Isleham Parish Council 20030170

SUNNICA ENERGY FARM EN010106 Volume 8

8.52 Update by the Applicant on Heritage Matters and Substation Connection (REP3A-037) and Sunnica Ltd Deadline 5 Submission - 8.47 Environmental Masterplan (REP5-054)

Isleham Parish Council wishes to comment on the proposals set out in these reports relating to the potential impacts to the B-50 bomber crash site close to Isleham at Site E05.

Drawing Title
**FIGURE 10-14E
LANDSCAPE MASTERPLAN
SUNNICA WEST SITE B**

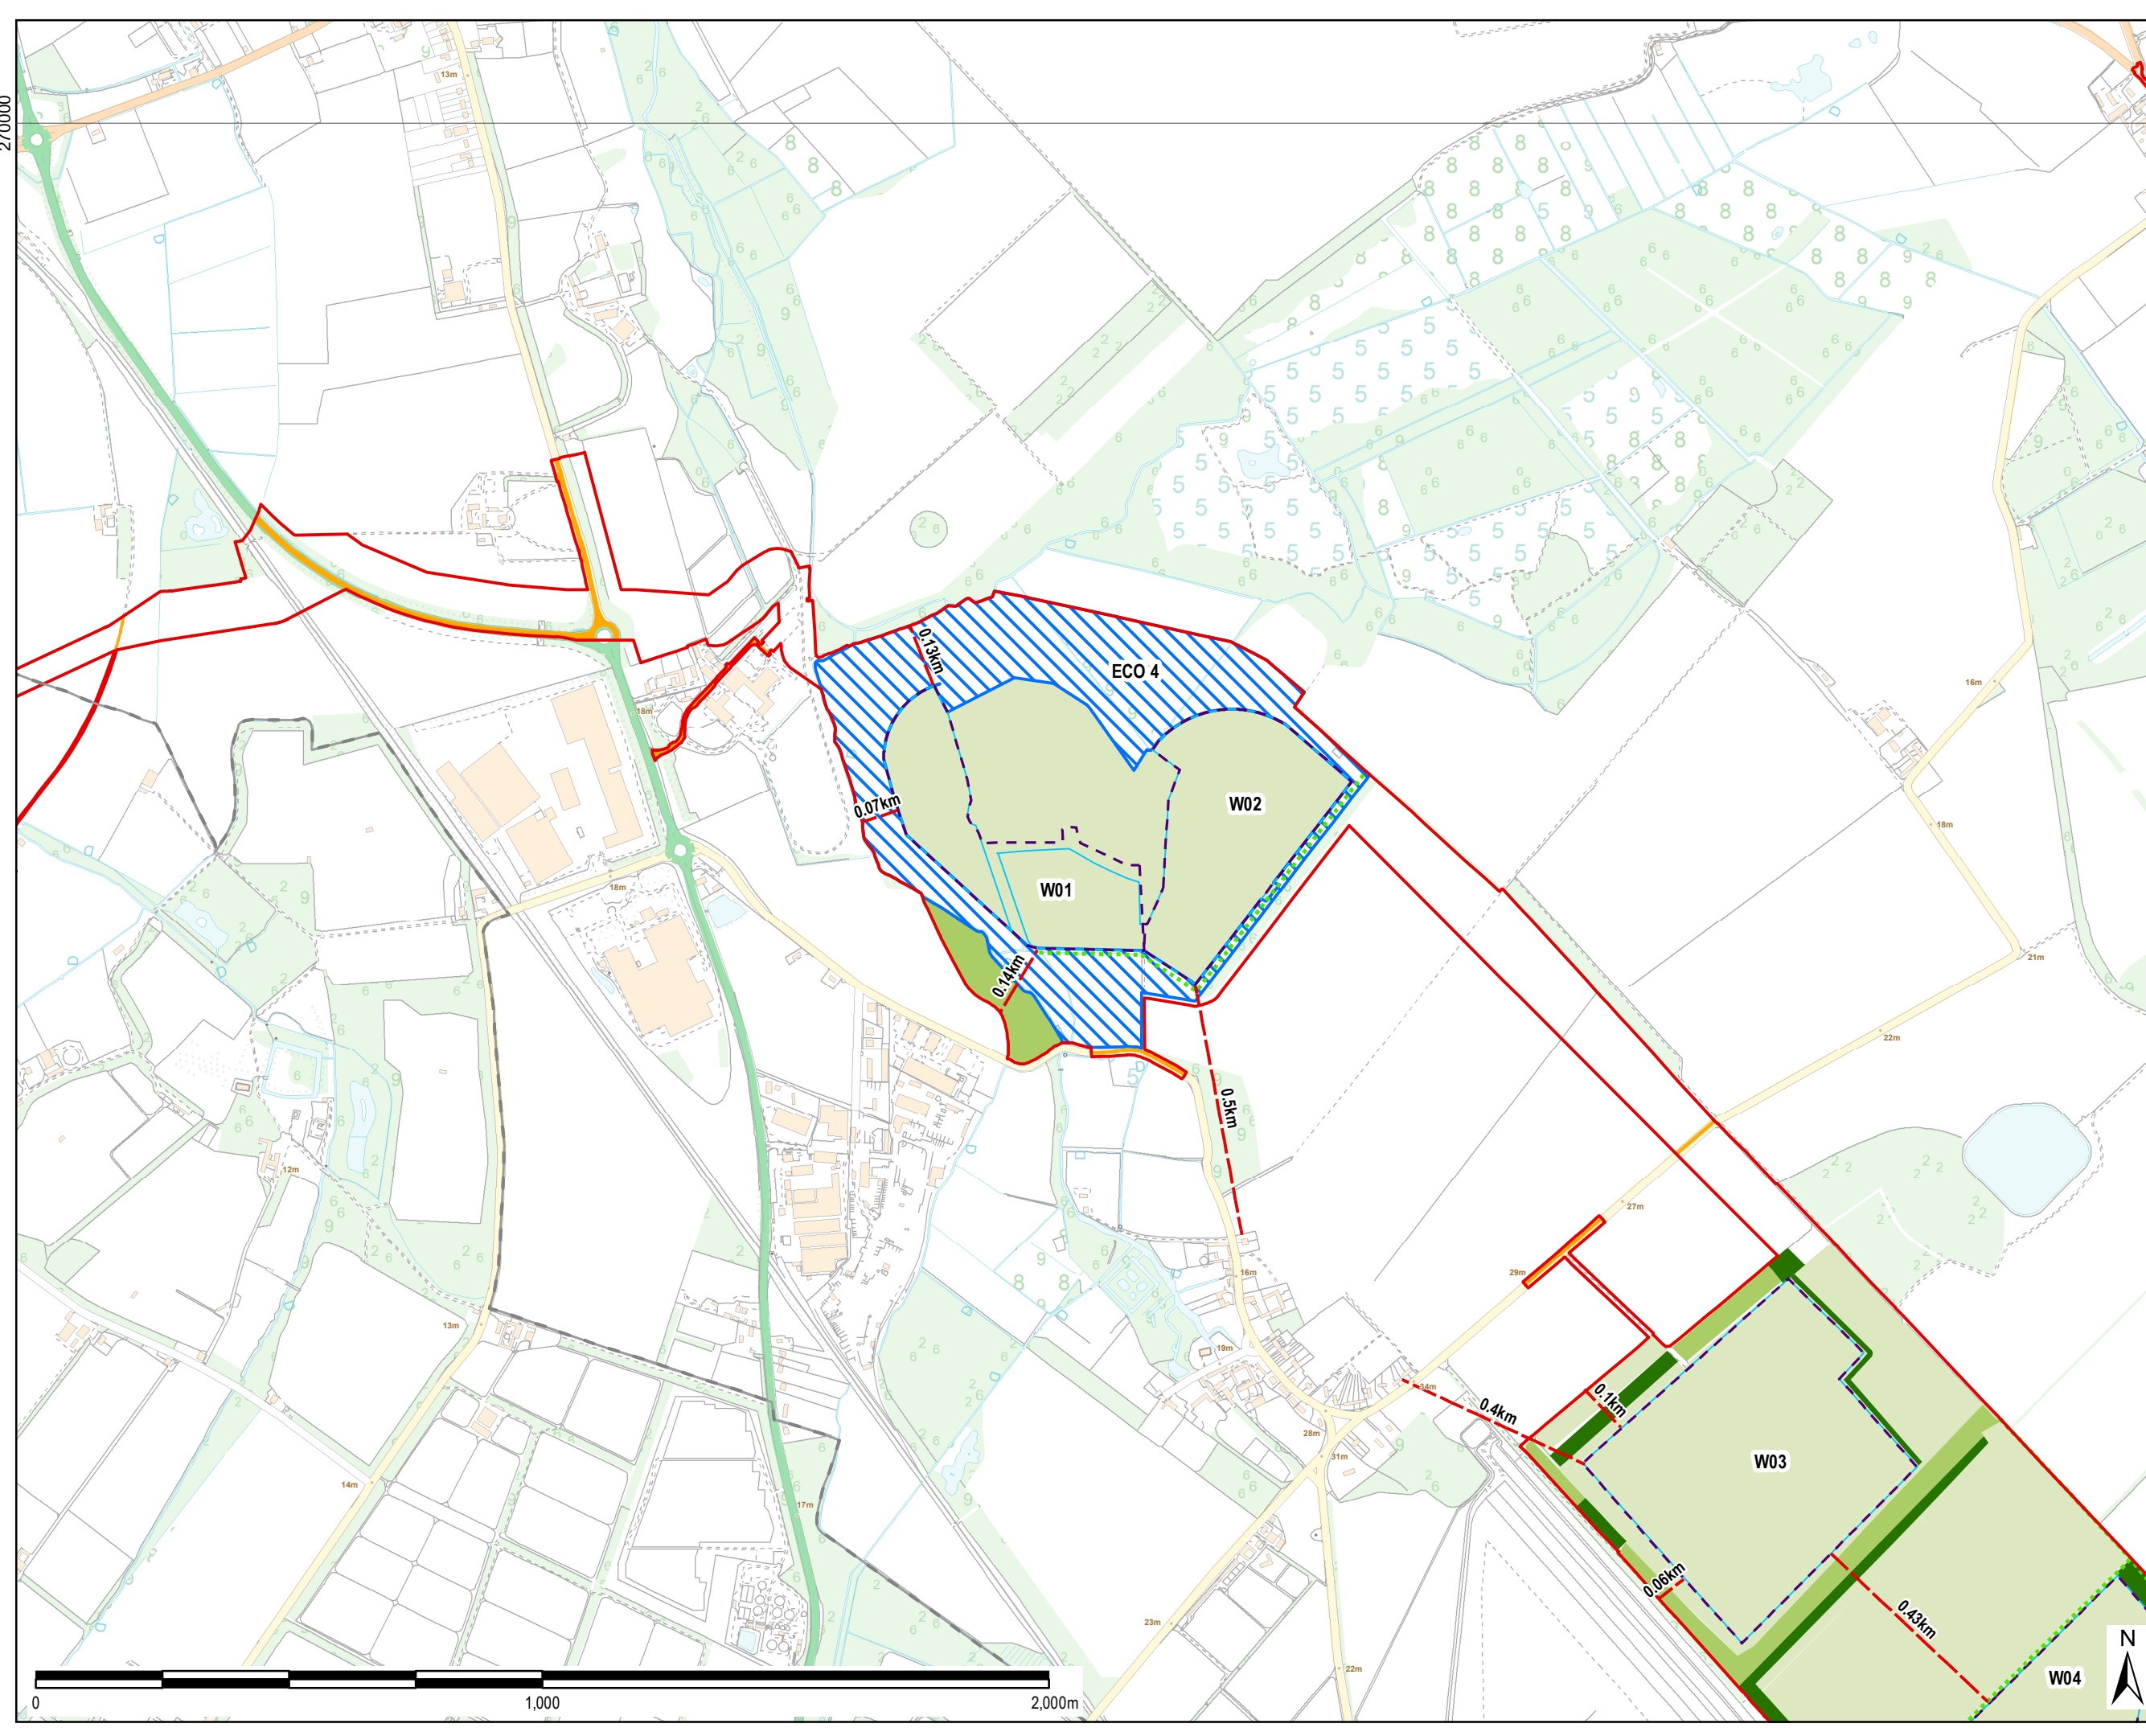
Figure 1 – taken from D5 submission 'after works plans'. The green square centre left is the proposed crater exclusion zone. The geophysical survey show that remains of the craft and crew were scattered over a much greater area than the excluded area. This exclusion zone would be completely surrounded by panels, which would themselves be surrounded by trees and hedgerows. The visual access and connection from the village and to nearby airbases would be lost forever.

What is abundantly clear is that if the excluded area proposed of 50 sq metres is accepted, it would be completely surrounded by the development of solar panels and the proposed hedging and wood to screen the development. That visual link from our village to the site will be lost and with it a part of our history, to be replaced by an interpretation board. The interpretation board will point readers to an area which cannot be seen as it would be surrounded by solar panels hedges and a wood. That essential link we have, from the village, Sheldricks Road and Beck Road will be lost and that natural connection with our history will be gone. Hardly a fitting commemoration.

landscape and seek to justify this through the Landscape and Visual Impact Assessment (LVIA). However they further go on to explain that the latest Environmental Masterplan submitted at Deadline 5 (REP5-054) shows further amendments to E05, planting along the Lee Brook and a new permissive path trying to mitigate this loss of landscape and views from the elevated position of the village. This will still result in the cherished views over this area being shortened, materially changed and lost forever. The views to our neighbouring towns and villages of Mildenhall and Worlington would be closed off.
